**Consultation Response from KC,
Trees****2022/91477 Land off Lindley Moor Road, Lindley, Huddersfield, HD3 3SX****Hybrid Planning Application for the erection of an industrial unit for E(g)/B2 /B8 use with associated access, parking, groundworks and landscaping in conjunction with an outline application for mixed use development use class E(a), E(b), E(g), B2 and B8****Date Responded: 19/8/22****Responding Officer: Matthew Moss****Responding Ref:**

Project Name: Lindley Moor Road	Drawn: TH	Checked: MB	<b>FOR PLANNING</b>		
Drawing Name: Landscape Masterplan	Date: April 2022		E	MB	07.09.2023
Drawing No: DR-4823-01	Scale: 1:500 at A0		D	TH	27.09.2022
			C	TH	24.05.2022
			Rev	Drawn	Date

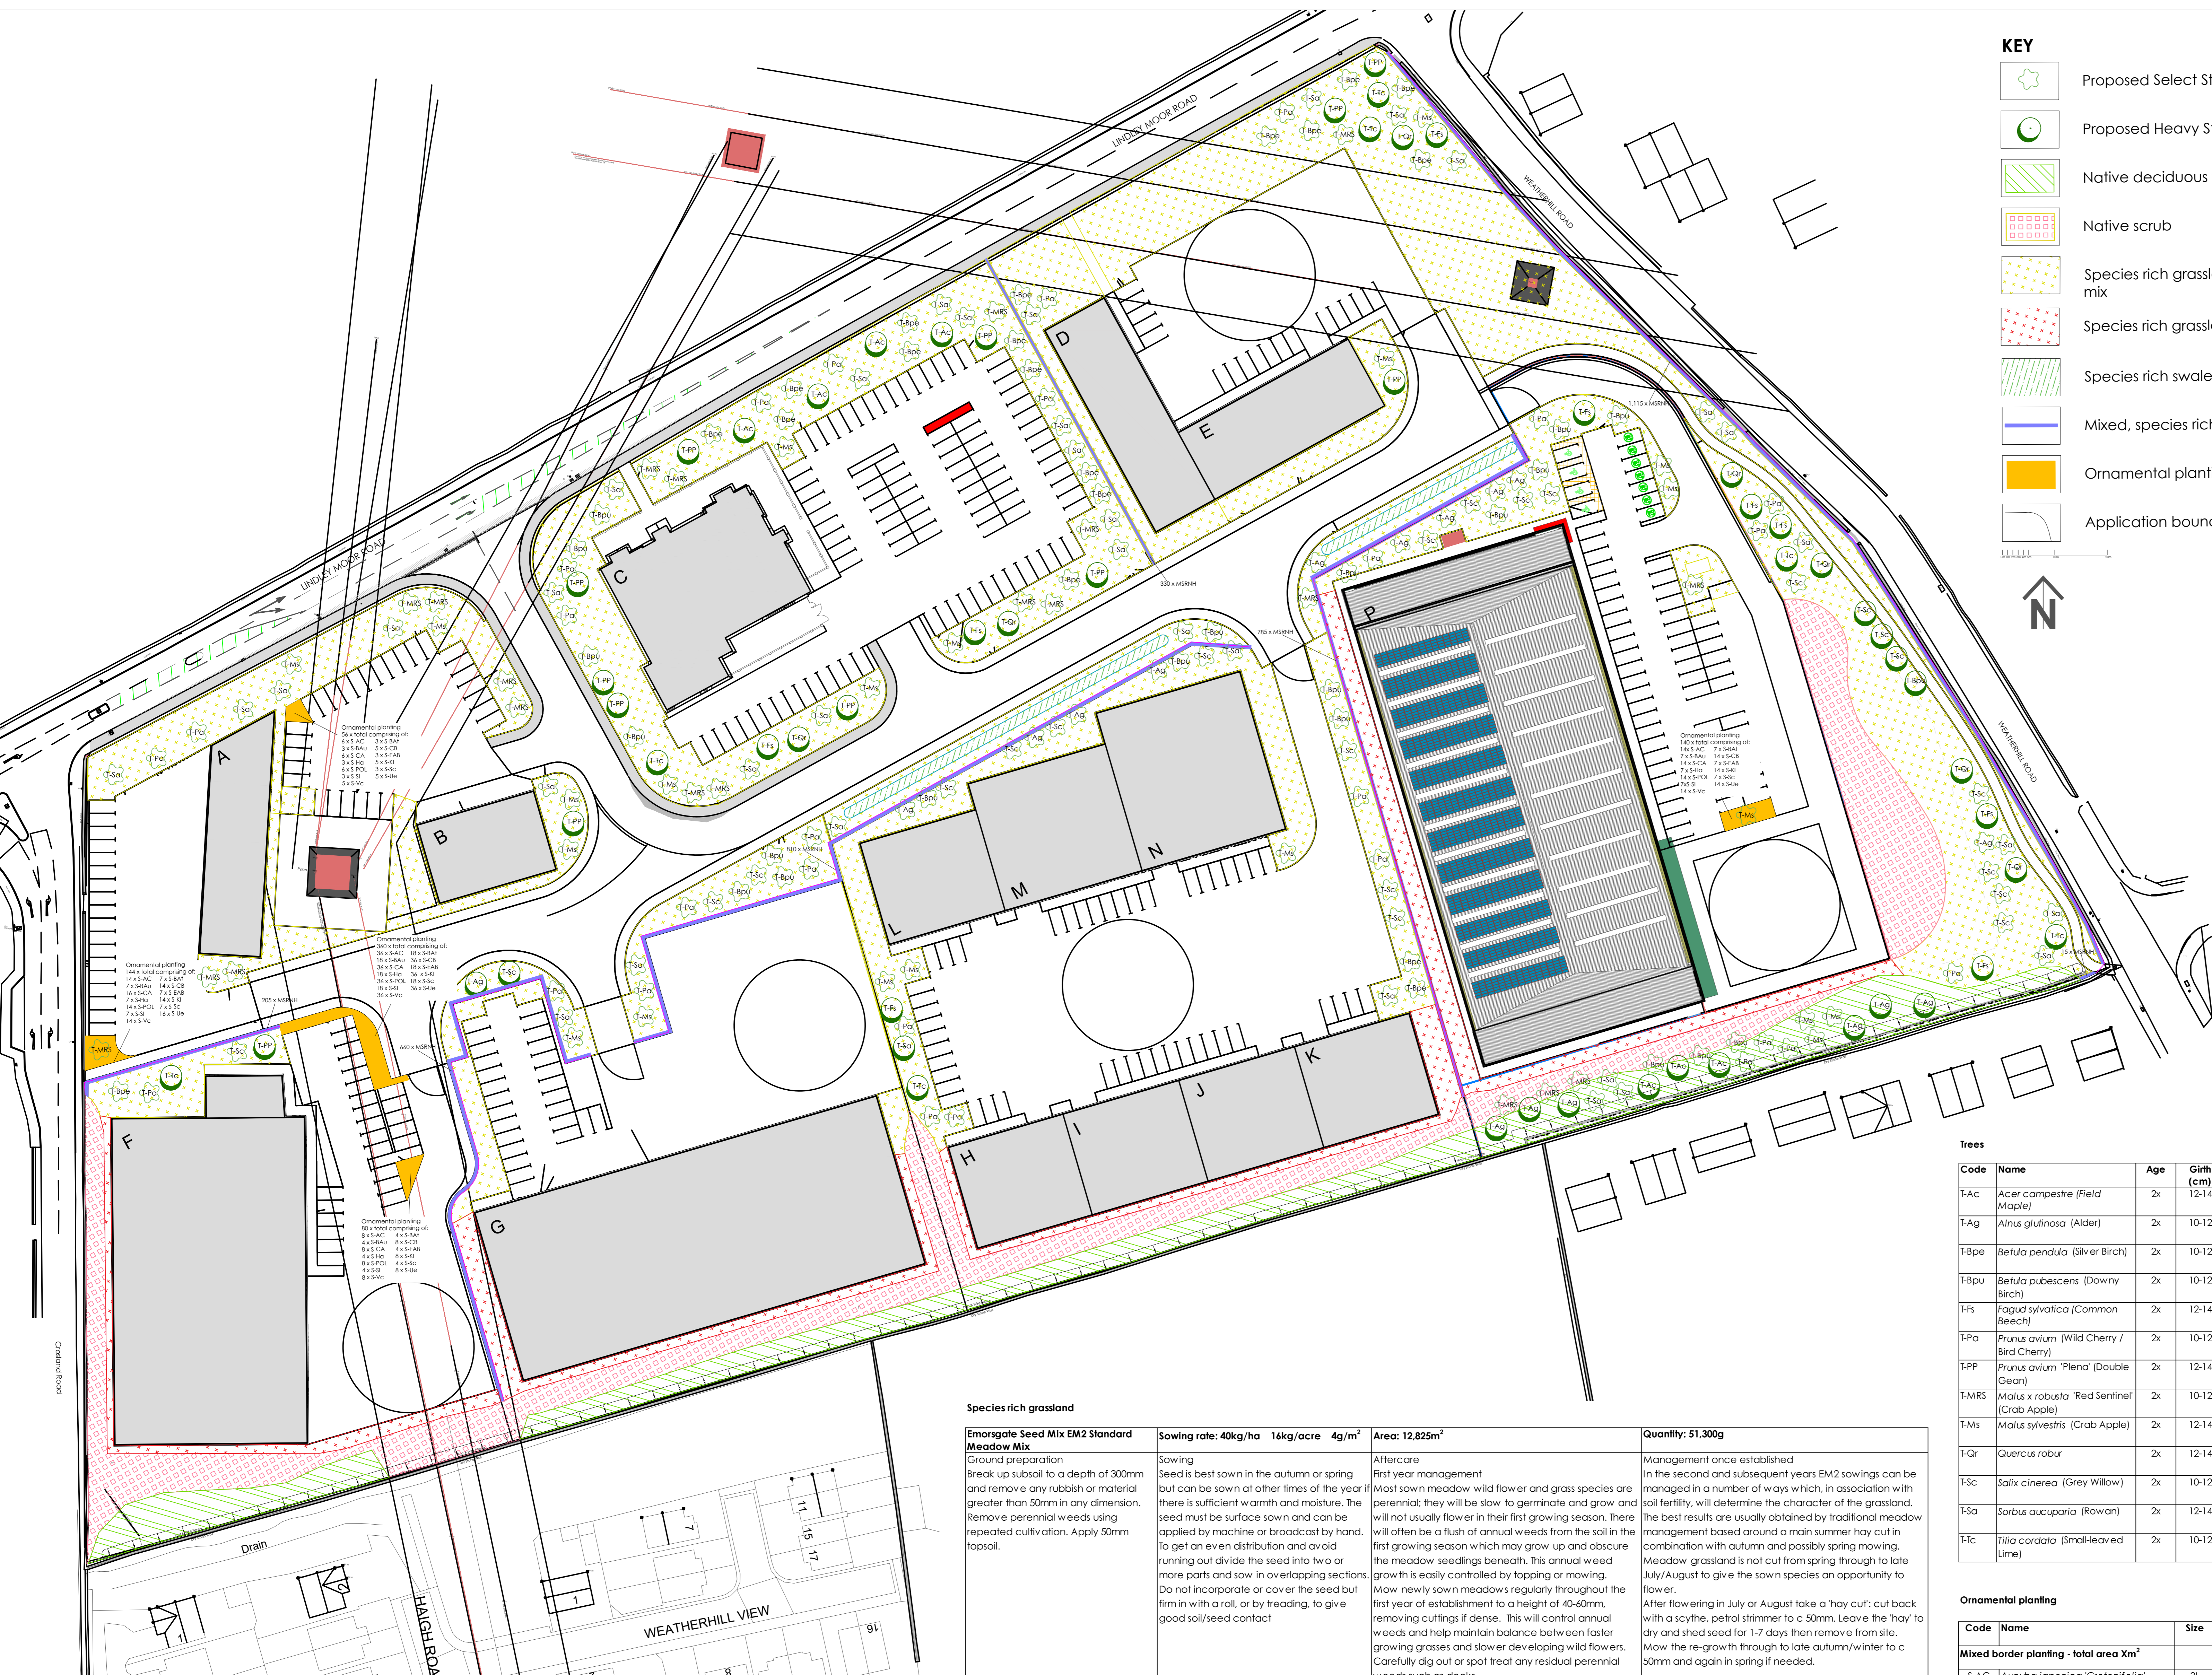
There is very little existing tree cover on site and the landscape masterplan shows a lot of new planting which is very positive to see.

My only comments would be that I think the tree planting scheme could be improved further by increasing the overall number of trees across the site, introducing some larger growing species of trees in suitable places and more consideration given to the species and characteristics of trees in relation to where they are being planted.

While the smaller trees are ideal for restricted spaces and narrow verges there are opportunities on this site for larger prominent trees to be placed. I can see that there are restrictions from overhead services to consider but these should be easily designed around to prevent unnecessary future maintenance.

I suggest that there could be more tree planting both internally and around the perimeter which would aid screening, create additional wildlife habitat, tree line the streets and I also think there are a lot of good tree planting opportunities being missed within the large car parking areas with the current design which would be ideal for installation of underground cells providing suitable rooting area for successful tree establishment.
